*Rolling Hills 2016
File # 2*

KOLONG HILLS COMMON
 File # 2

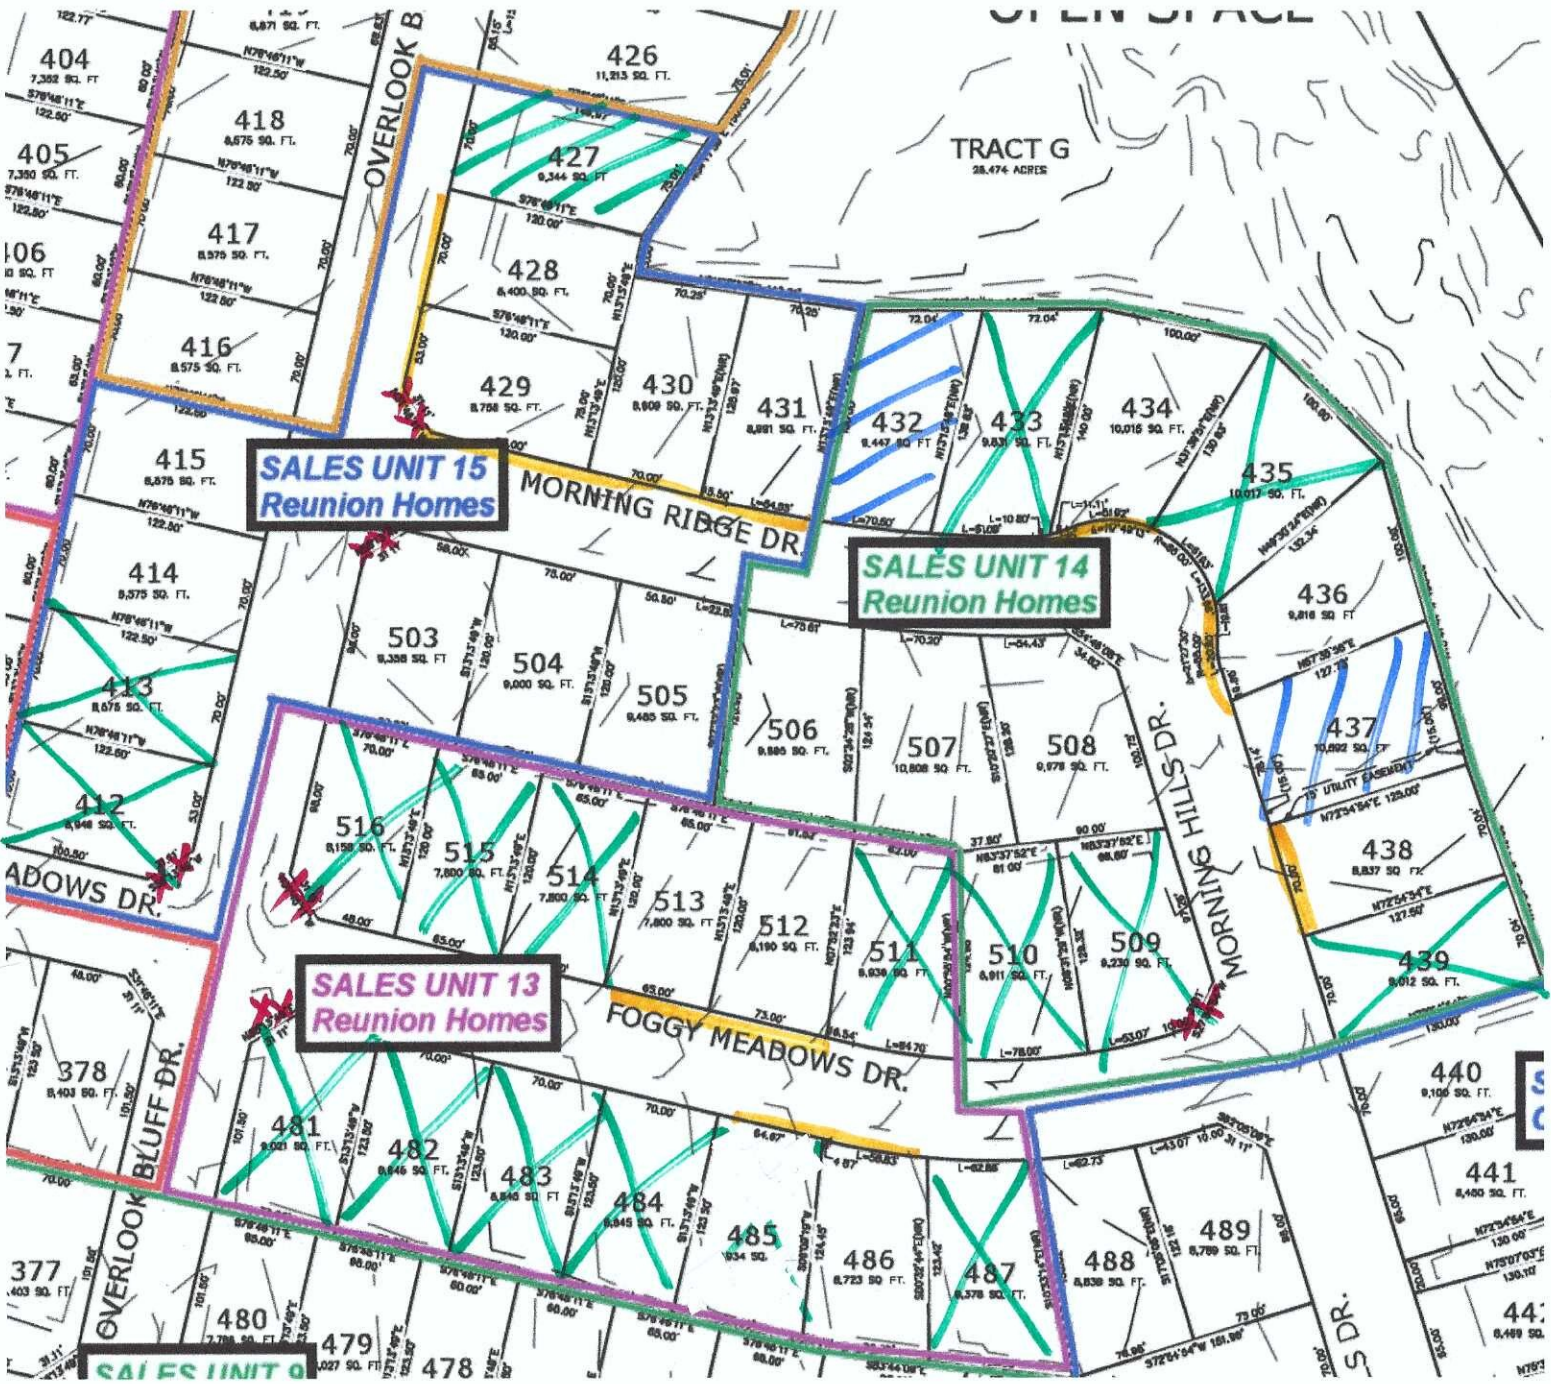
At a minimum, the GEC Plans should clearly show the limits of construction (i.e., the permitted area), specific control measure types, and general direction of flow.

Refer to the example GEC plan sent via email/uploaded to this submission request.

506 is owned by ZRH per County assessor's records
BESQCP issued so should be shown as an active lot.

507 and 508 are closed per County assessor's records

485 is owned by ZRH per County assessor's records

BESQCP issued so should be shown as an active lot.

513 & 512 are owned by ZRH per County assessor's records so should be shown as an active lot.
